SANDSTONE PRECINCT

DESIGN REVIEW PANEL - ADVICE 10

4 October 2019

EDUCATION BUILDING

Proposed beam detail

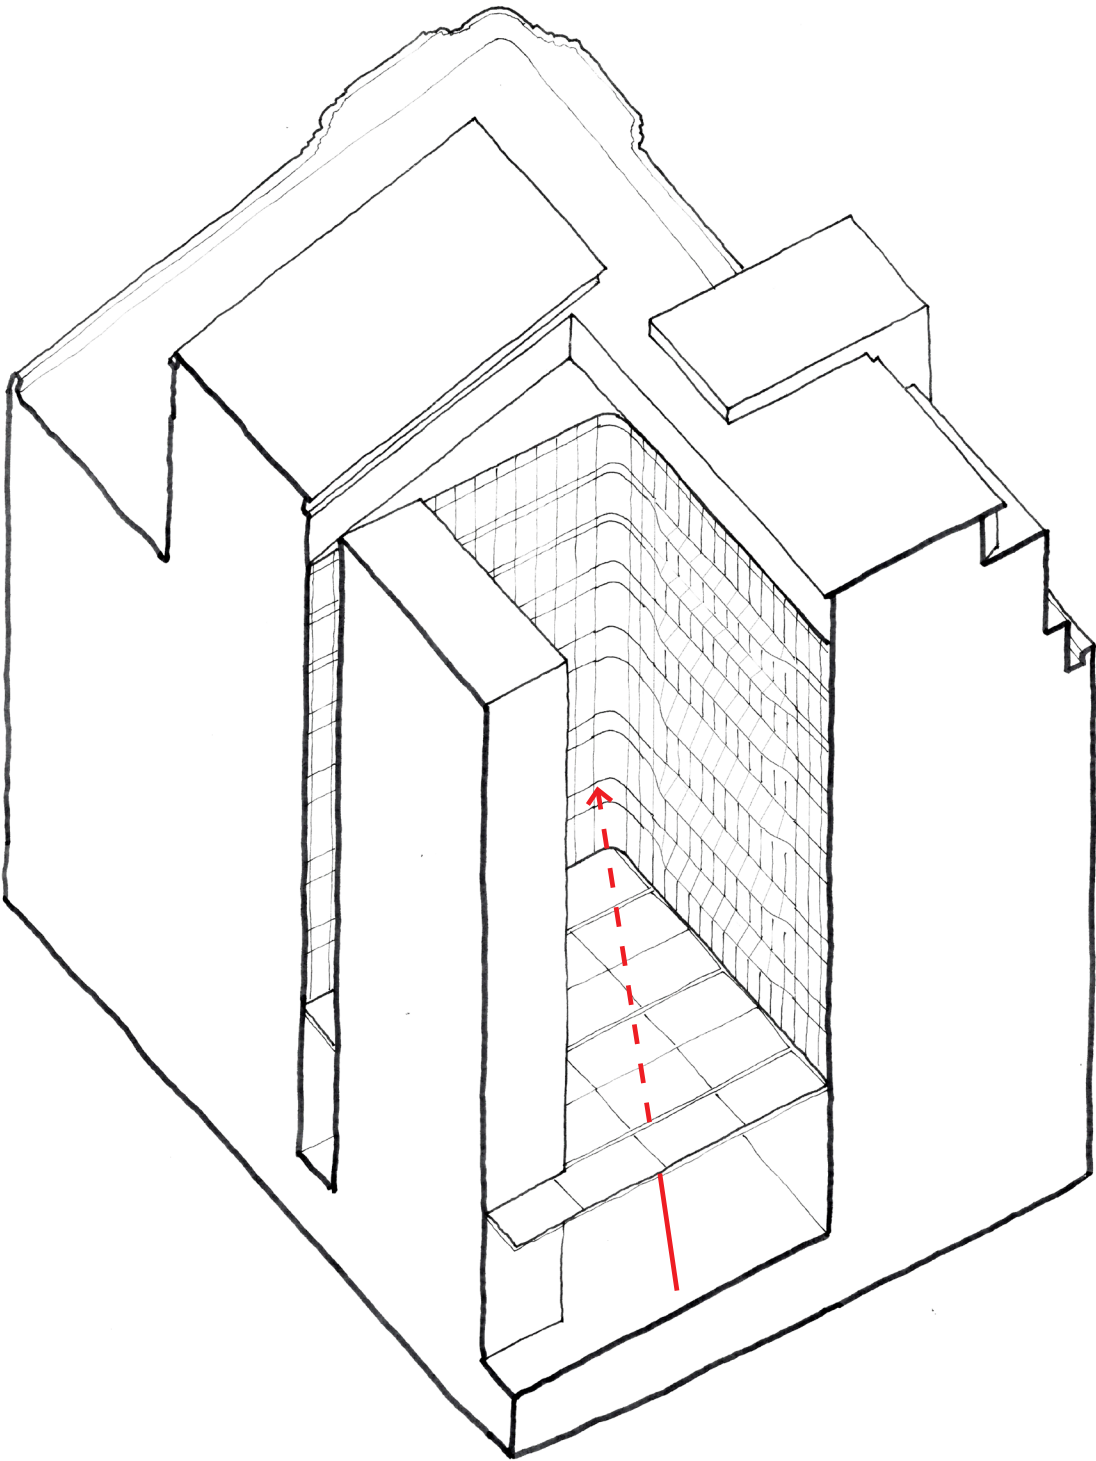
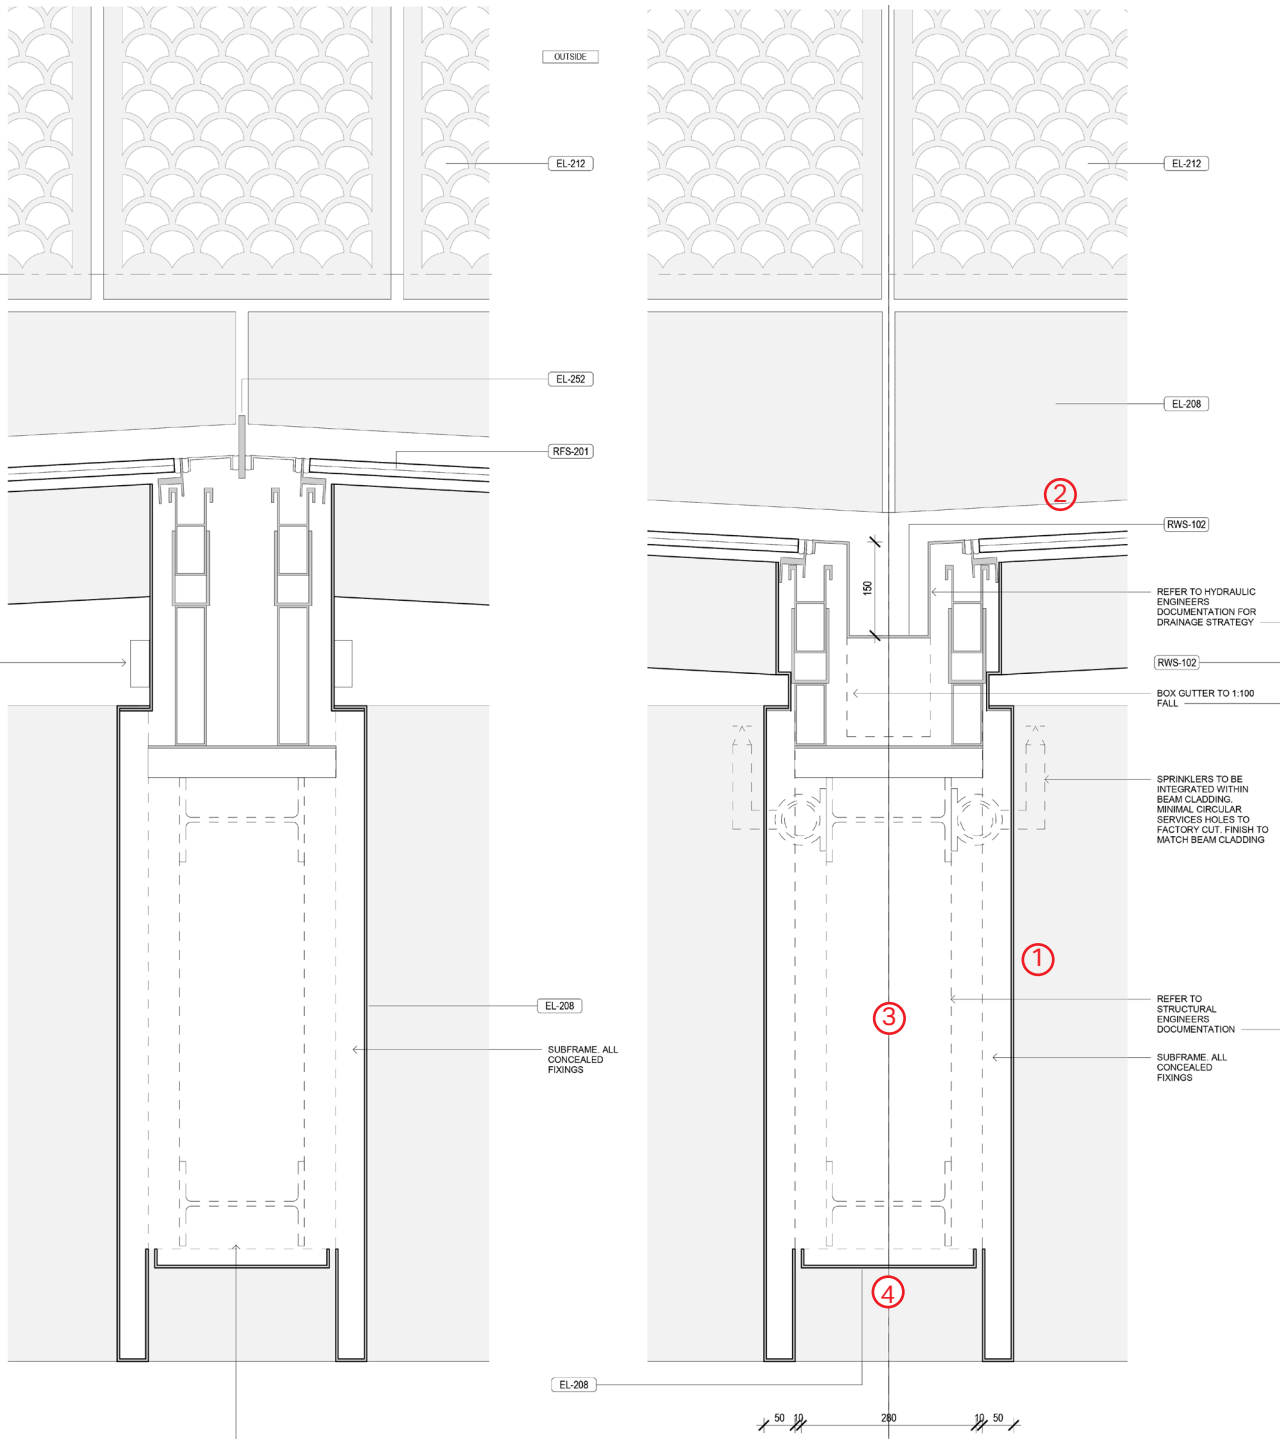
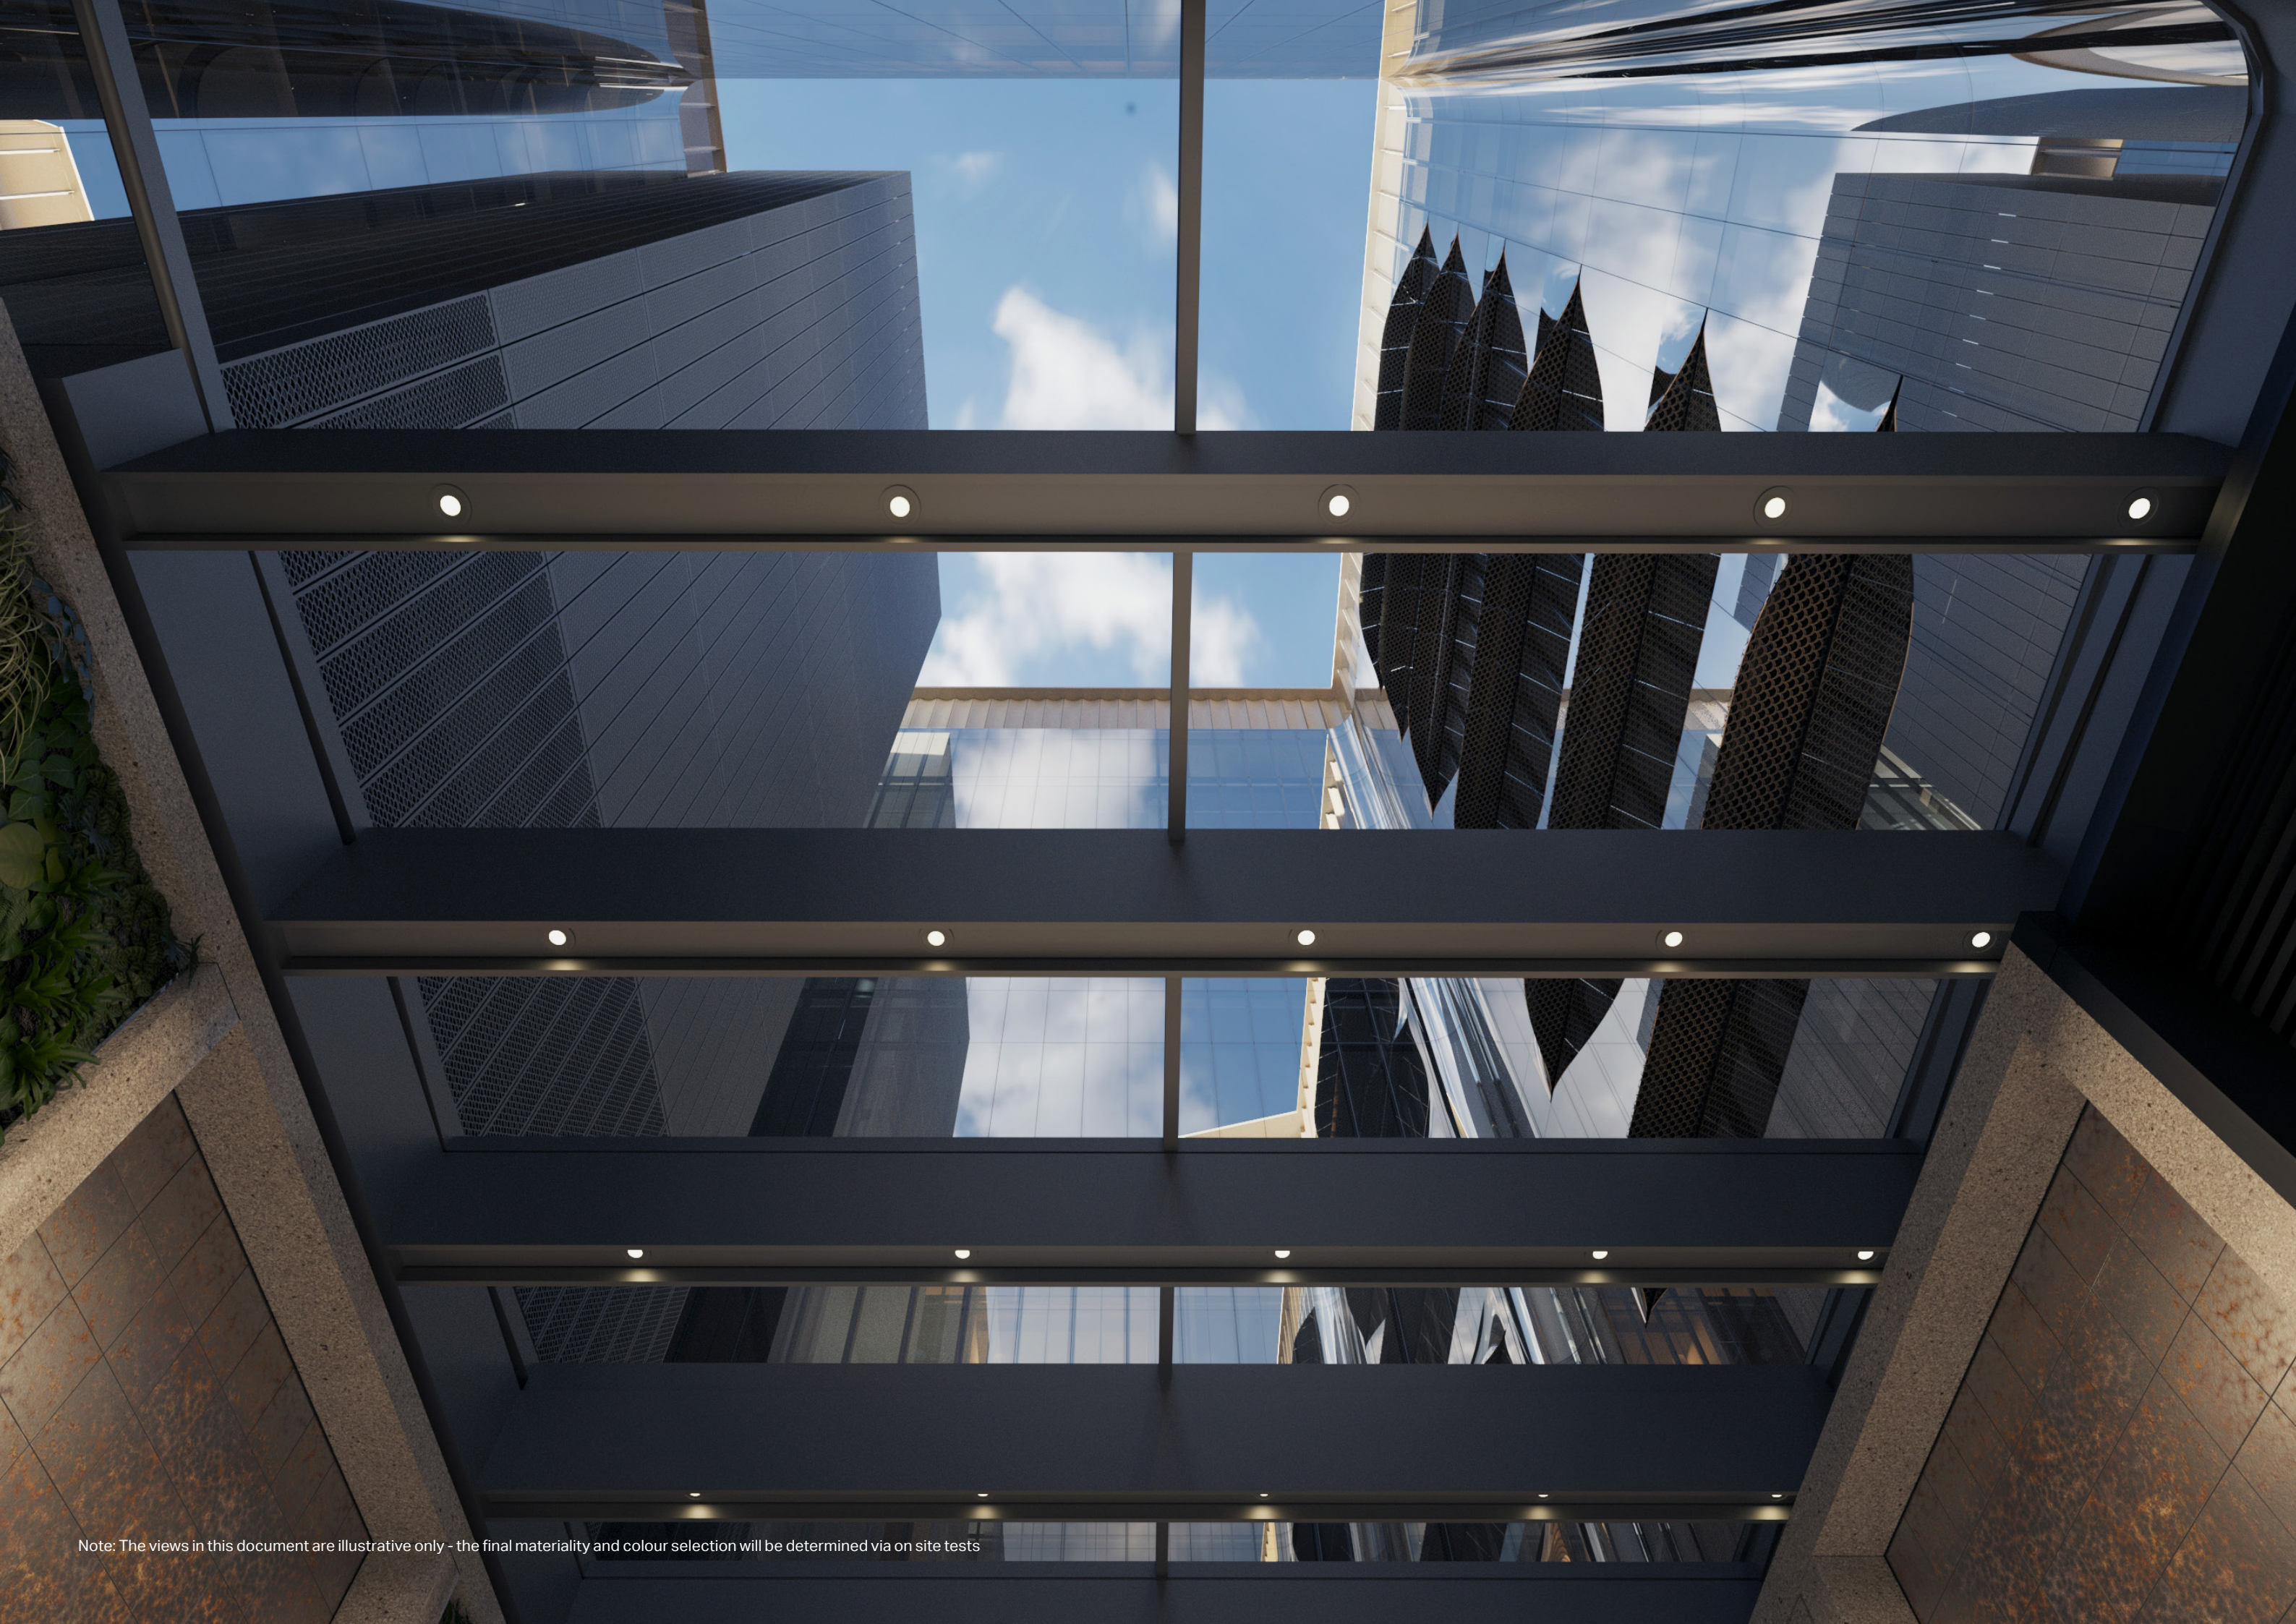
- . The internal walls to the courtyard will be full height glazed panels, the window planters have been deleted,
- . The precast roof beams have been replaced with steel beams clad with charcoal toned PPC aluminium finish.
- . The lift shaft cladding has been replaced with charcoal toned PPC aluminium finish, with incorporated ventilation panels.

The Panel believes that the full height glazing needs to be better aligned with the new room layouts, the alignment of mullions with walls should be tested, and the reliance on blanked out panels with backing material should be minimised. The potential for the dark glass in the DGU to provide good natural light at the lower levels of the courtyard is questioned, as is the reflective quality of the glass, its potential impacts on client privacy and amenity and consideration of the visual performance of the tinted glass at night (transparency to the outside and reflectivity within the corridors). Any future presentations should also show the impact of changes to the cooling towers.

The latest courtyard package does not fully explain the architectural detailing and the Panel requests updated details of the facades (glass, metal, etc), and sectional details of the glass roof.
